CITY OF PORTLAND BUILDING PERMIT

PERMIT ID: 2013-00264

has permission to **44' x 14' one story addition connected by deck to main house (two bedrooms, 3/4 bath and sitting area)**

From: Paul Stevens <PStevens@SMRTInc.com>
To: 'Jonathan Rioux' <JRIOUX@portlandmaine.gov>
Date: 3/22/2013 1:11 PM
Subject: RE: 37 Fessenden Ave., LDI

STEVENS LDI
KEY PLAN - 1/8" = 1'-0"
12/27/12
EXISTING
1ST FLOOR - 905 SF
2ND FLOOR - 780 SF
TOTAL = 1685 SF
NEW 616 SF
GRAND TOTAL 2,301 SF

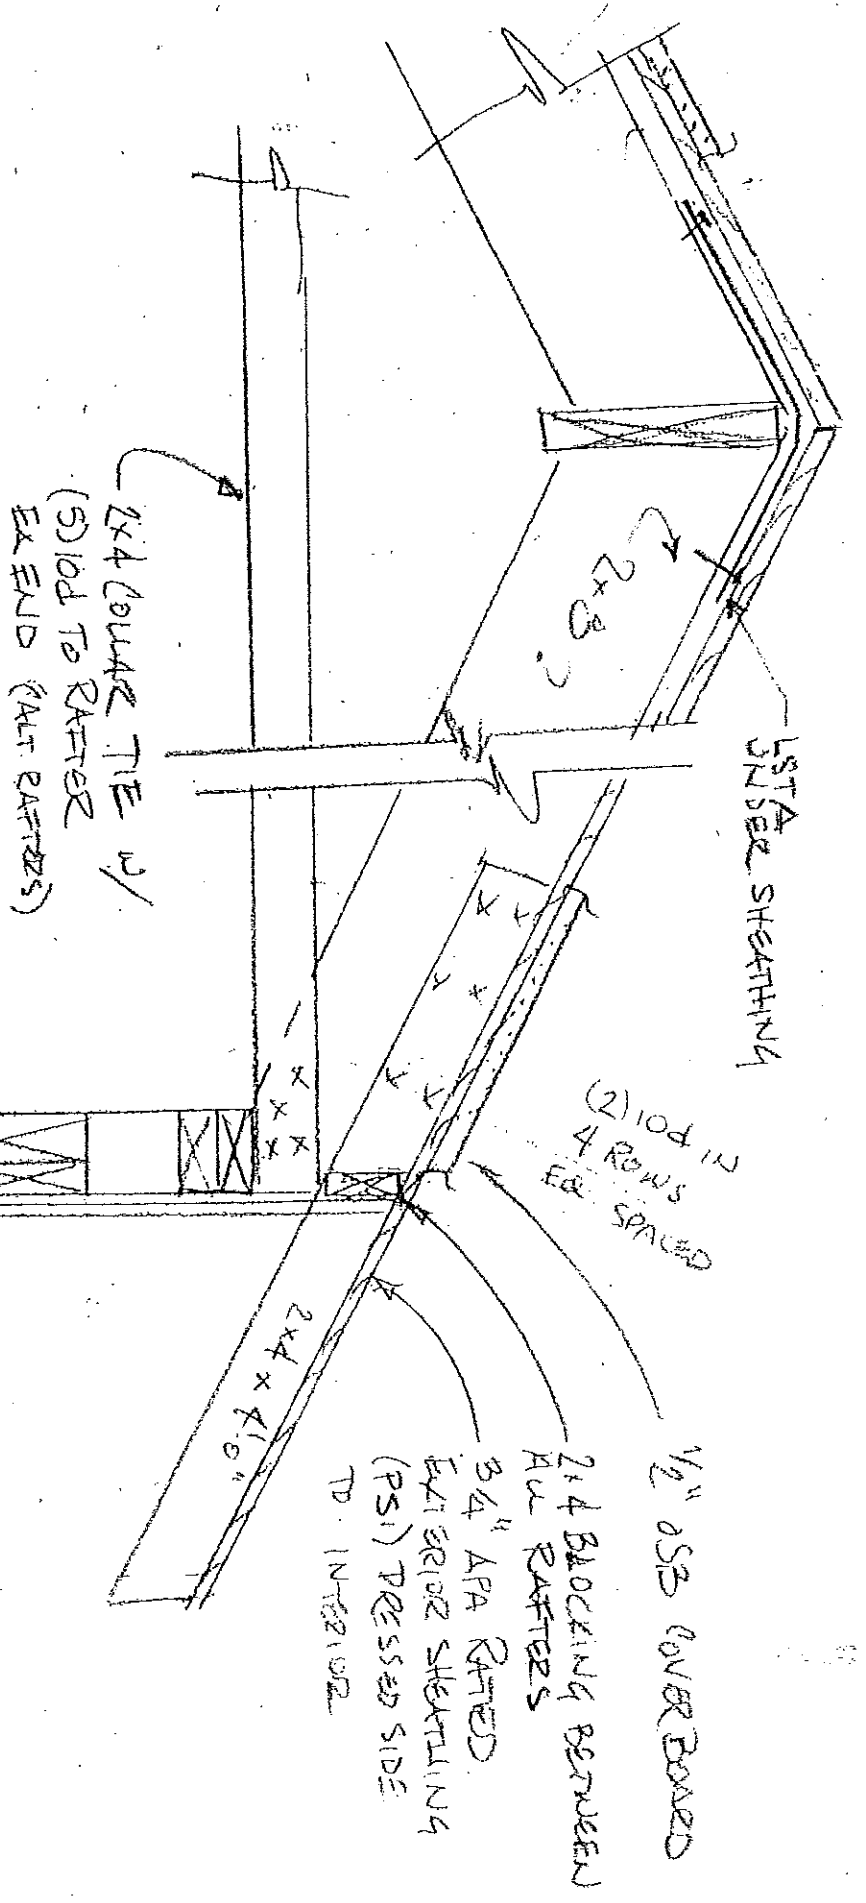
Is the new addition (out building) 50% or greater of the total existing structure? The Girder(s) supporting the flooring system/ room must comply with R502.5, are you proposing to span he (2) 2 x 12 inch SPF # 2's @ 11-10 1/4" max? Did the subsurface wastewater disposal system account for the addition's bedrooms/ fixture counts?

- 1) The area of the existing cottage is 1685 sf. The addition is 616 sf or 37% of the existing. See drawing no. 2 for the key plan and the area tally.
- 2) There are actually 3-2x12's spanning the 11'-10 1/4". The rim member directly above the 2-2x12's is the third component of this structural assembly for this span. See drawing no 14 –"Structural Section"
- 3) The existing cottage has 3 bedrooms. The new septic system was designed for 5 bedrooms in anticipation of this 2 bedroom addition

DETAIL TYPICAL PIER

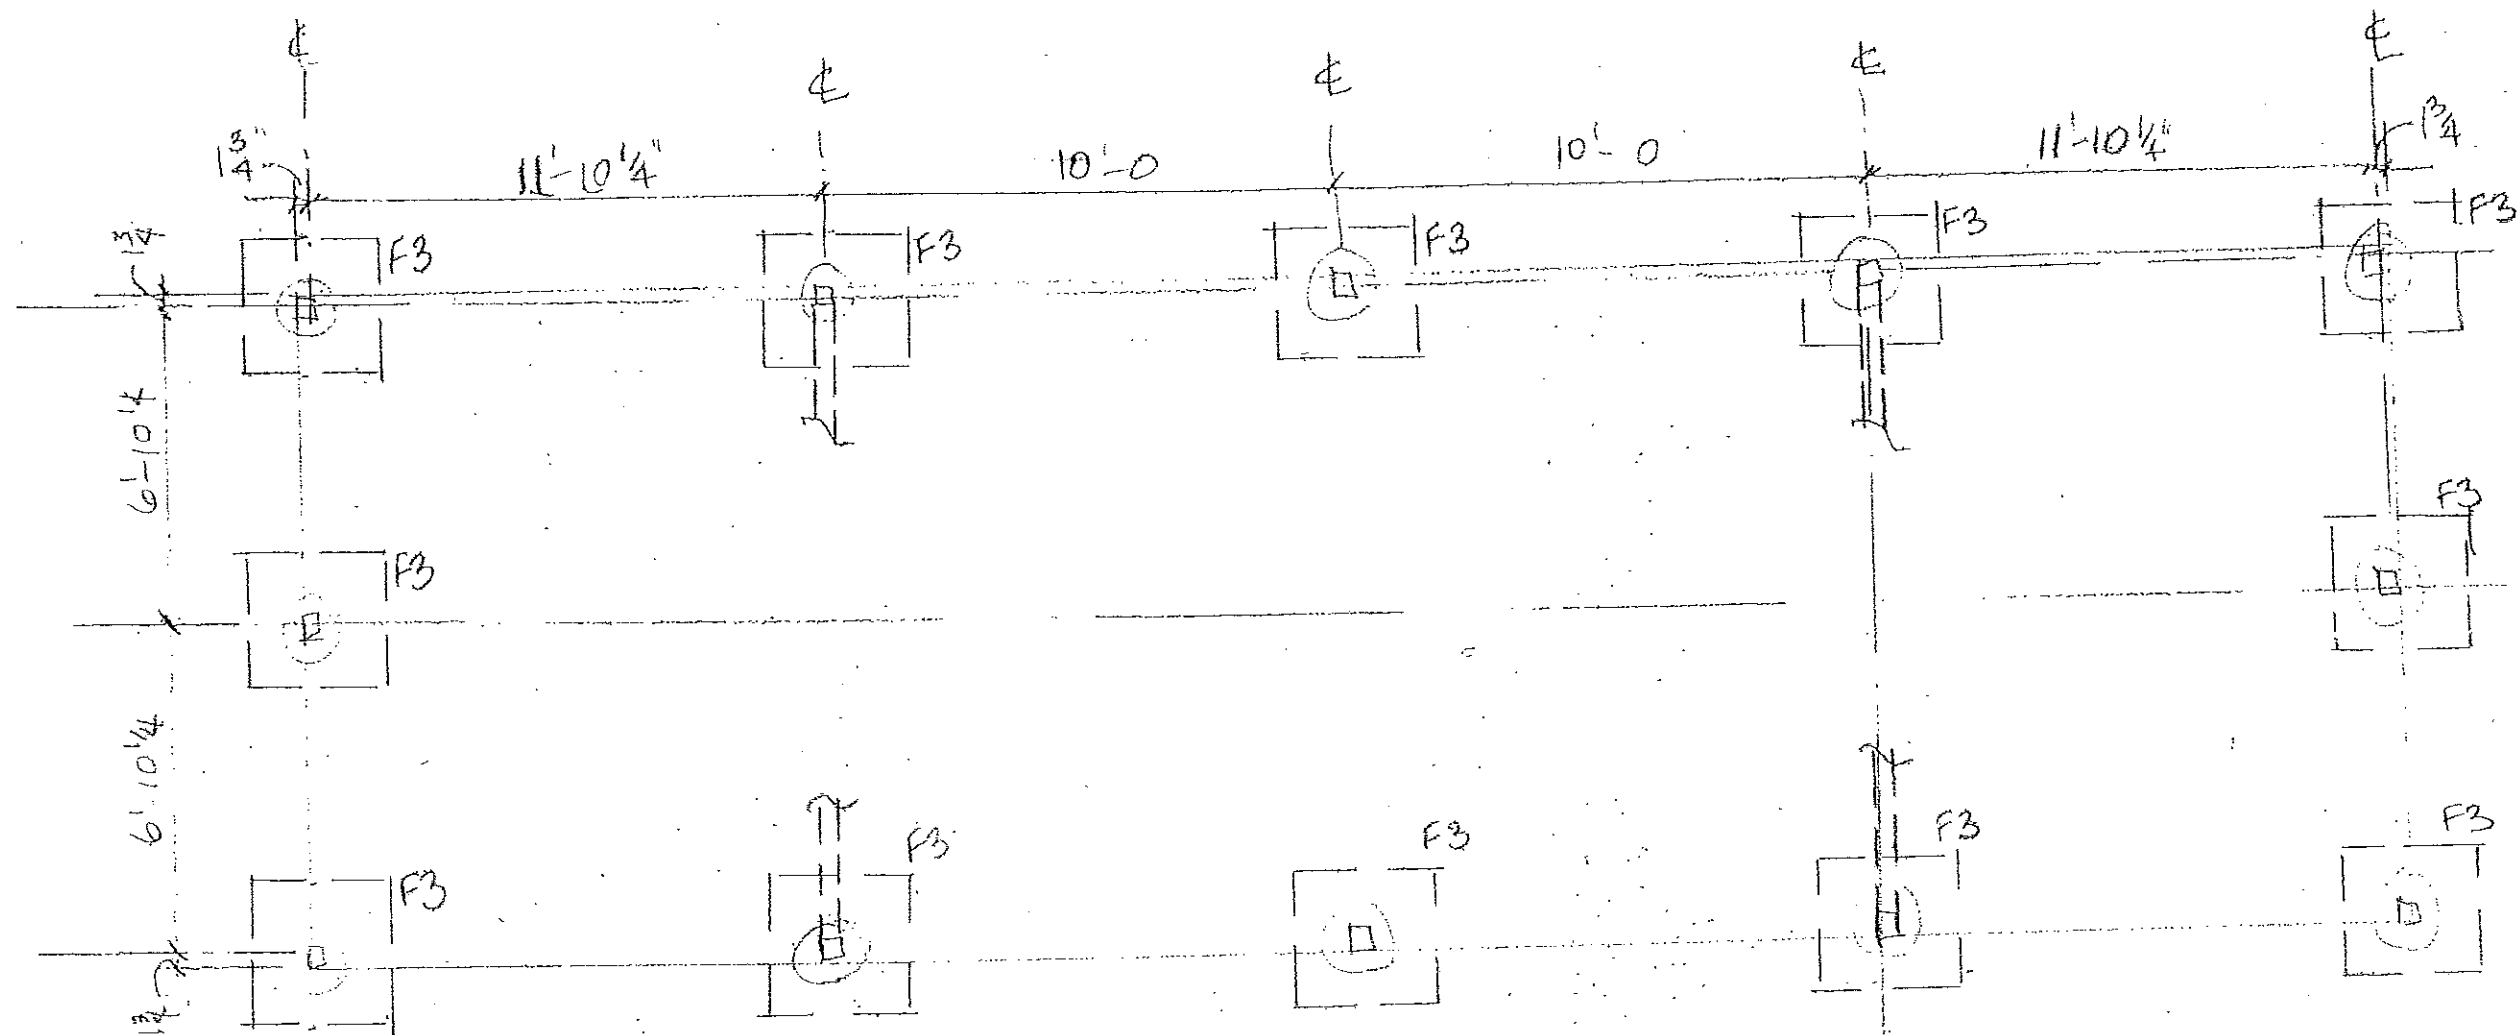
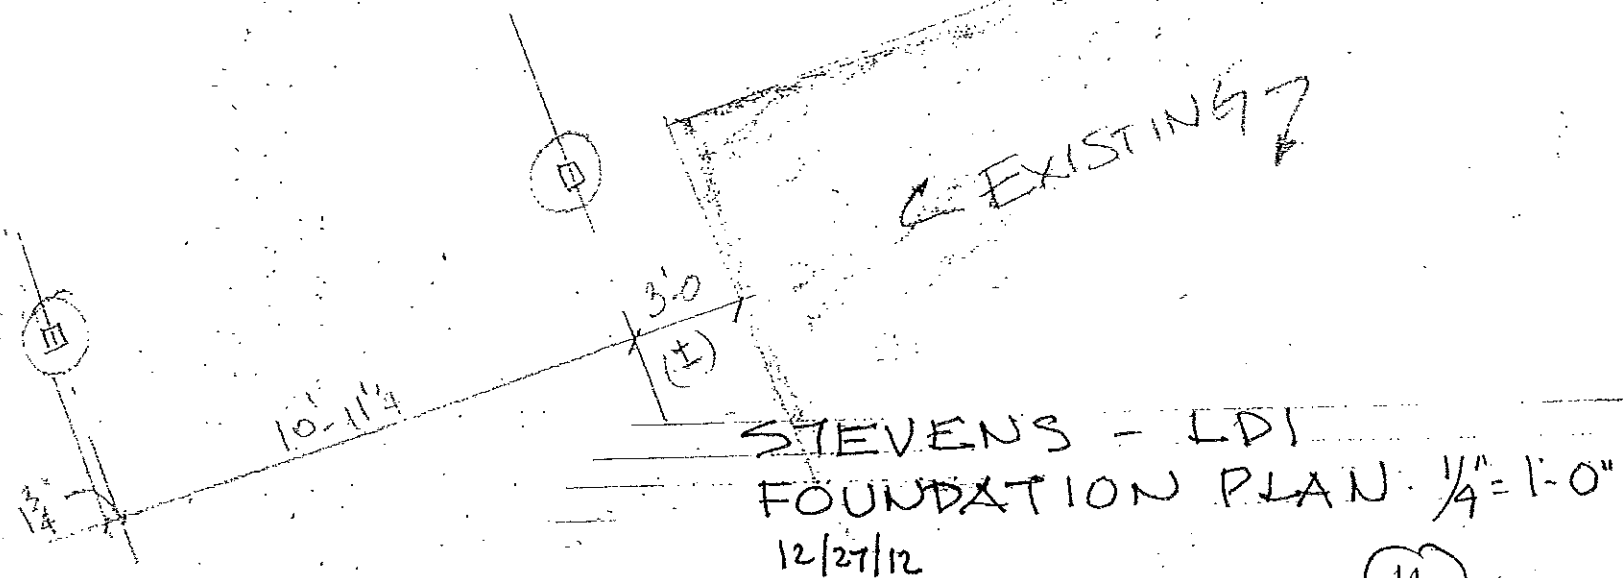
- 3) R401.2 Requirements. Foundation construction shall be capable of accommodating all loads according to Section R301 and of transmitting the resulting loads to the supporting soil. Fill soils that support footings and foundations shall be designed, installed and tested in accordance with accepted engineering practice. Gravel fill used as footings for wood and precast concrete foundations shall comply with Section R403

- 4) As discussed with the Owner- Ventilation/Access shall comply with Section R408.1 & R408.3 for the crawl space.
- 5) R404.1.2.2 Reinforcement for foundation walls. Where unbalanced backfill retained by the stemwall is less than or equal to 18 inches, the stem wall and above-grade wall it supports shall be provided with vertical reinforcement in accordance with Section R611.6 and Table R611.6(1), R611.6(2) or R611.6(3) for above-grade walls.
